7th November 2018

Two - storey extension to the existing Cafe in order to provide increased internal seating, multi-purpose space, with improved service & food preparation area, disabled access & bike storage at The Bluebird Cafe, South Drive, Ferring, BN12 5QU

Council Ref: FG/159/18/PL

02 PROPOSED WEST ELEVATION  
2003 Scale: 1:100

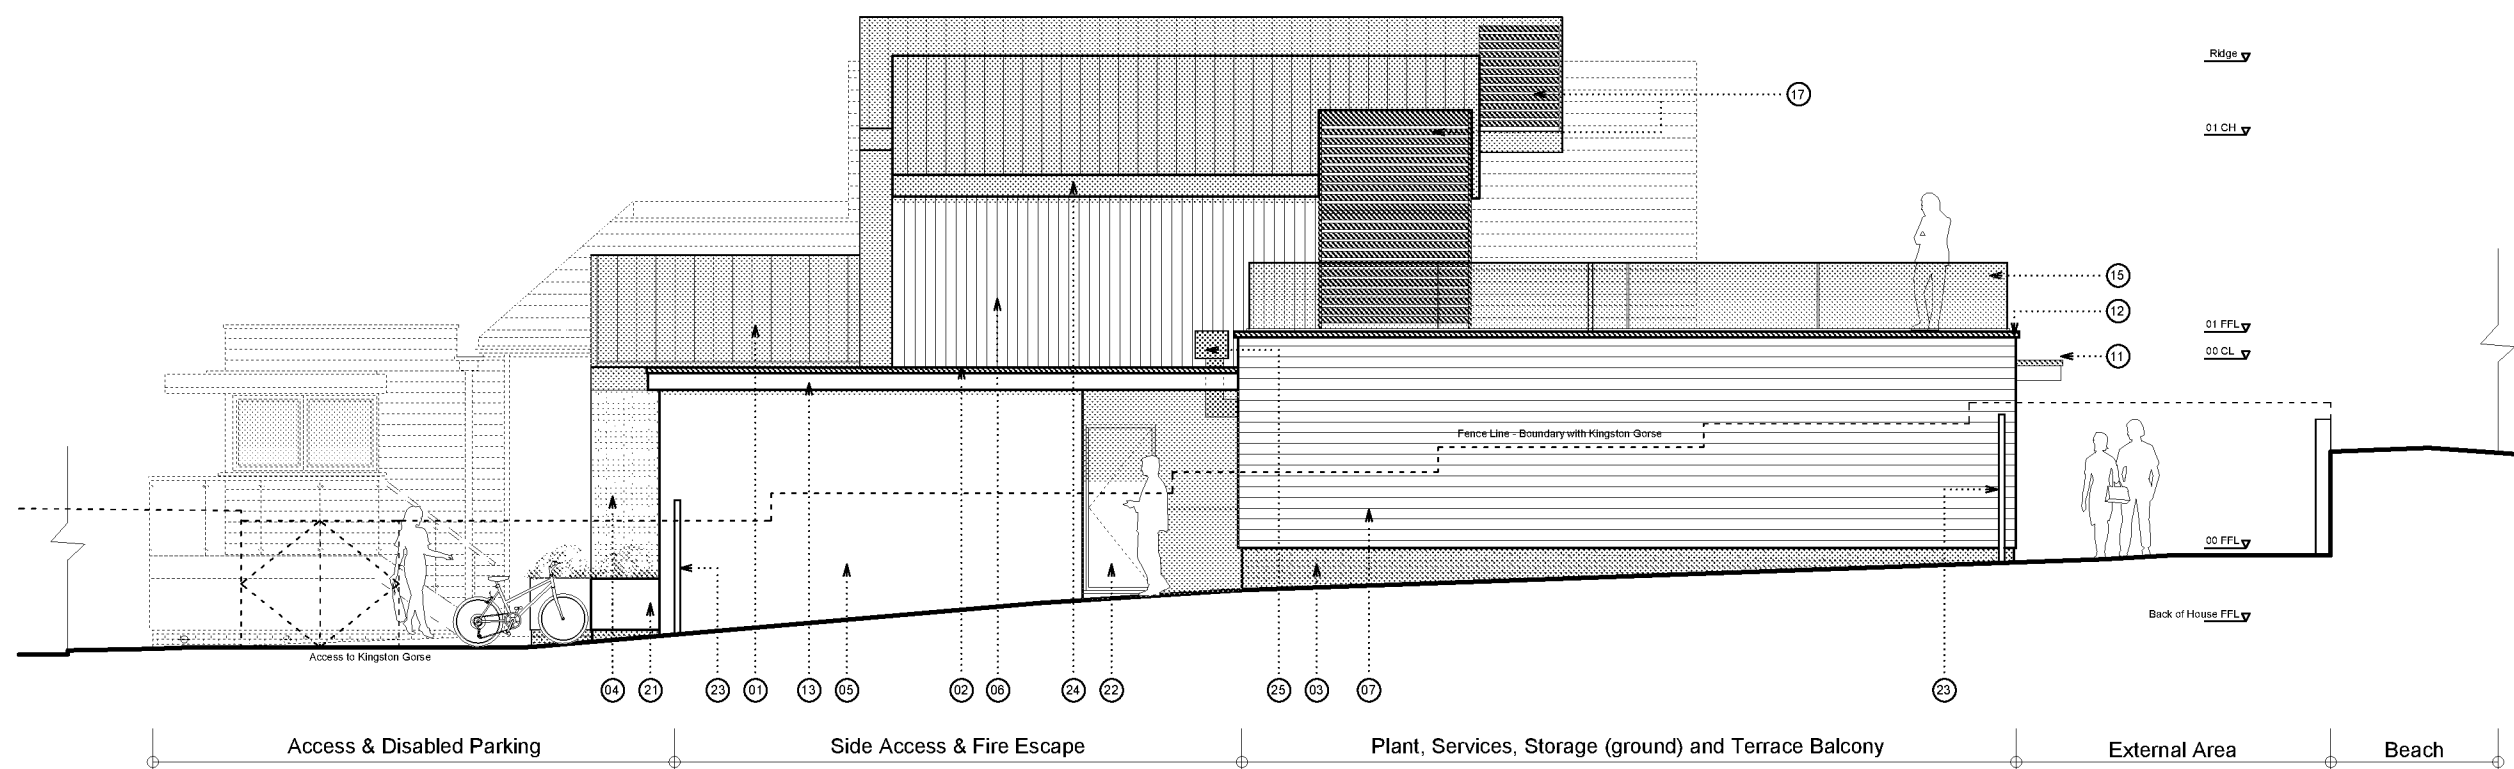
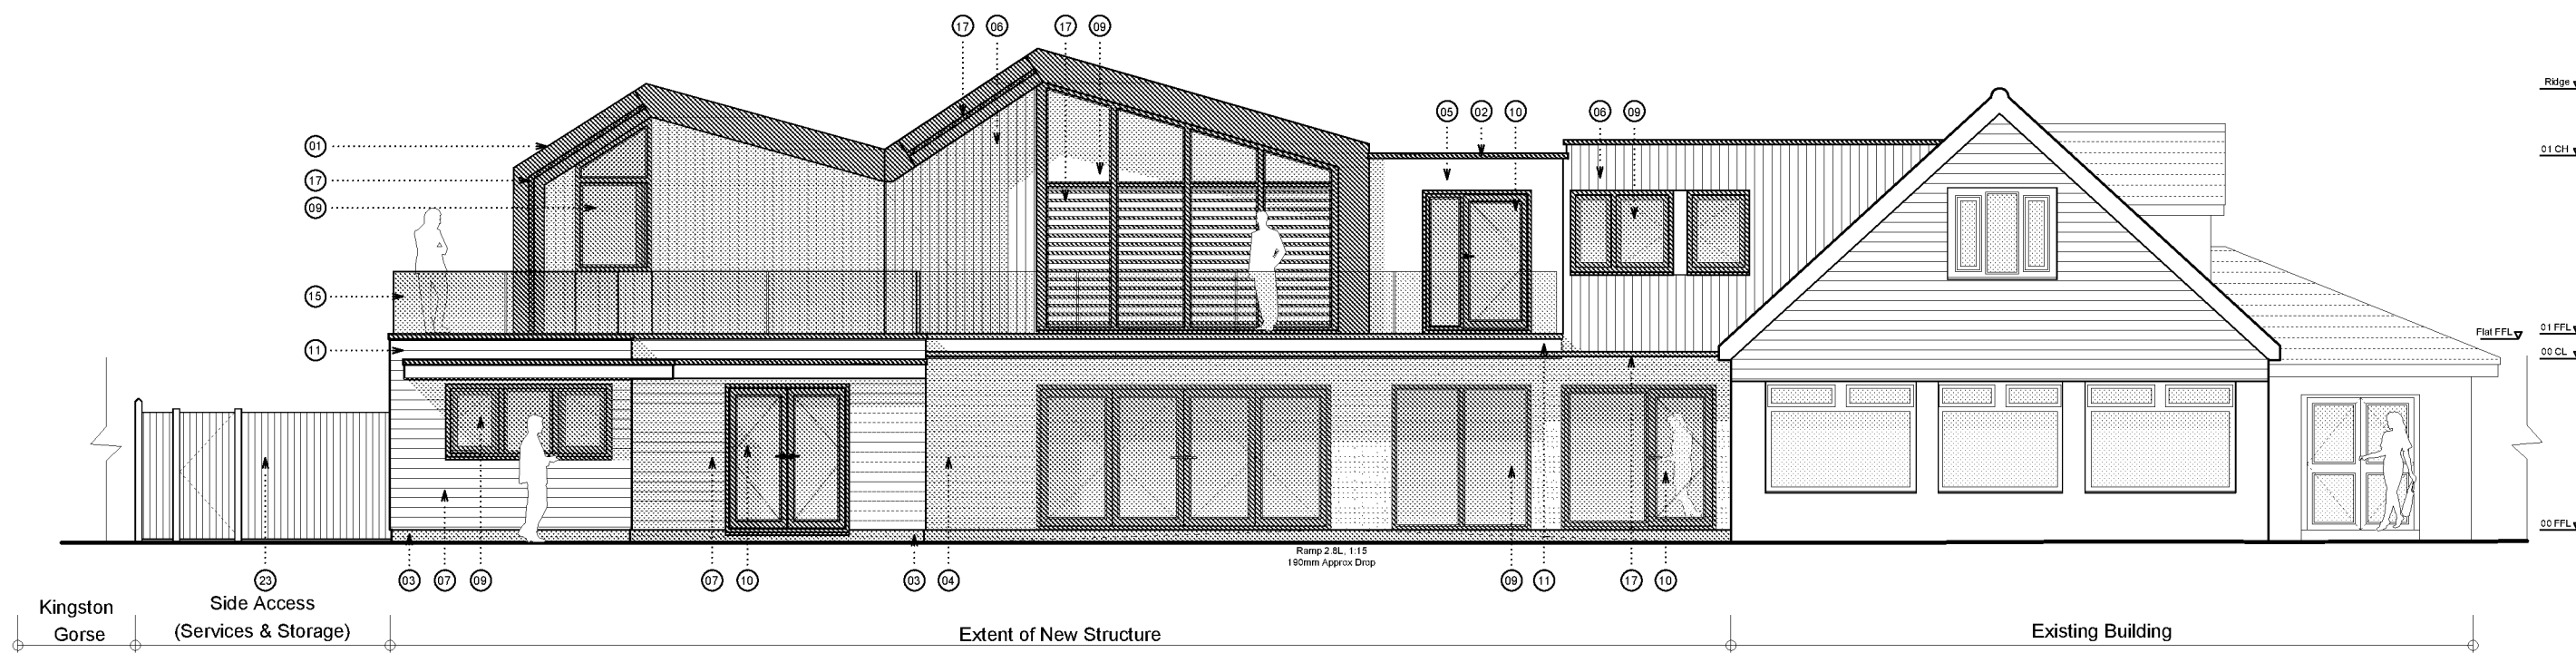
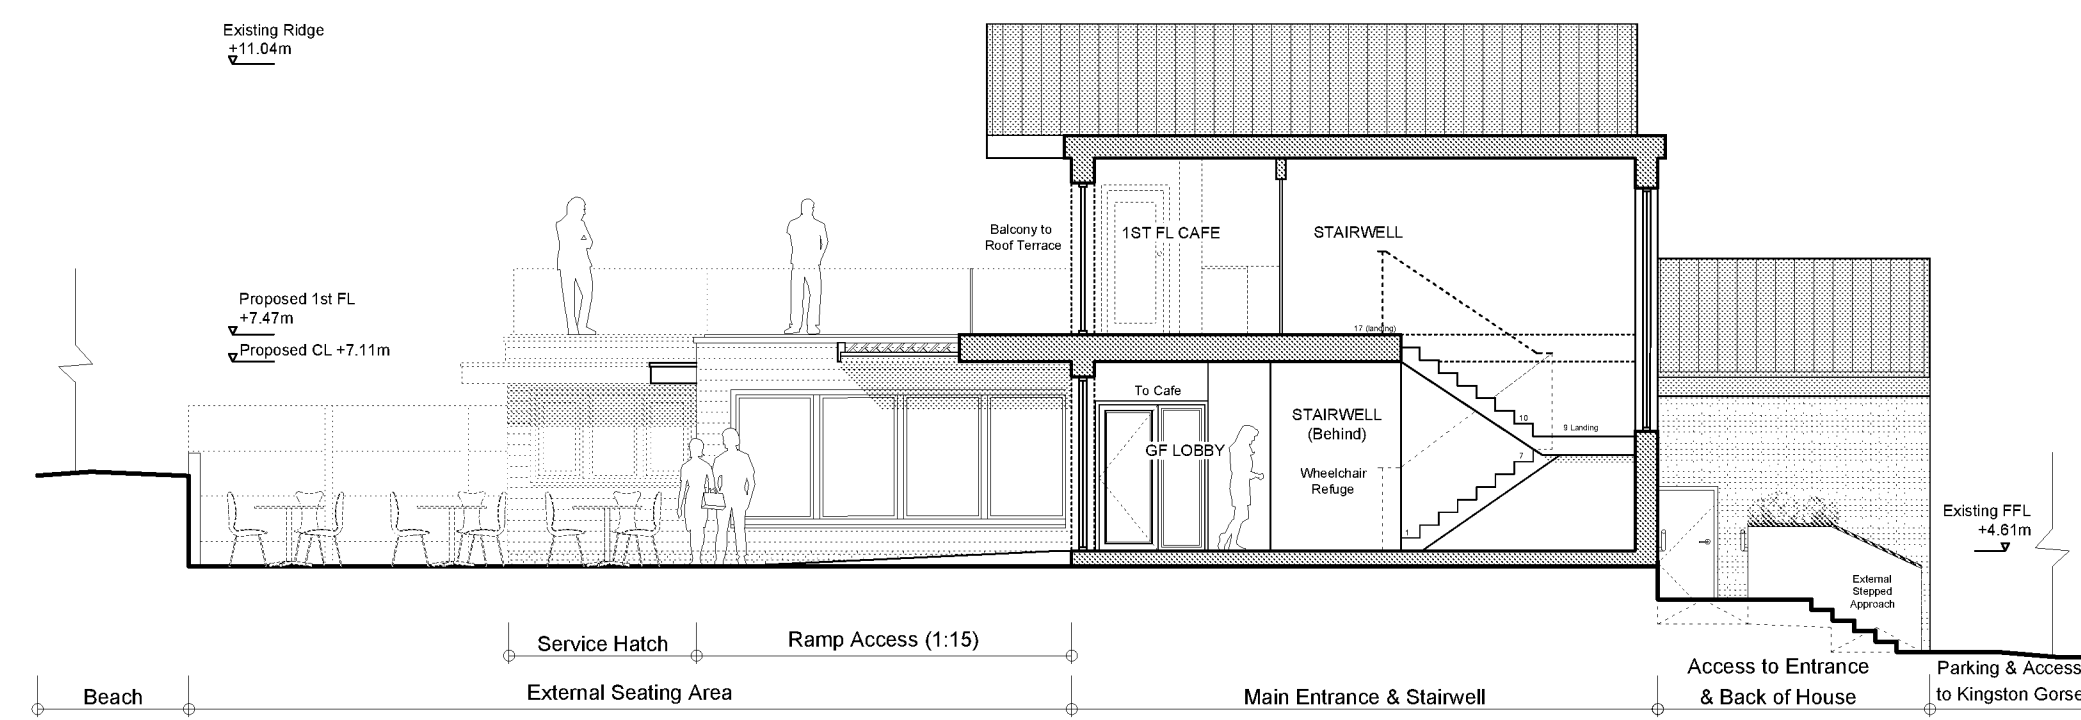
In addition, there would be a loss of residential amenity through overlooking resulting from the large terraced area. This is shown on drawing no. BCA200301 and indicates a large expanse of terrace at first floor level which would afford users of the cafe a view into neighbouring properties. It features what the plans describe as a "balcony glazing system". The people depicted on the plans tower above the "balcony glazing system" and it will do nothing to ameliorate the significant adverse impact of overlooking. If the Council is minded to approve the terrace area it should feature 2 metre high privacy screen on the west elevations and remove the windows proposed on the north elevations to protect the amenity of 'Kingston Gorse House' and its neighbours, although this approach would do nothing to reduce the adverse impact of noise or light pollution from the terrace as I explain above.
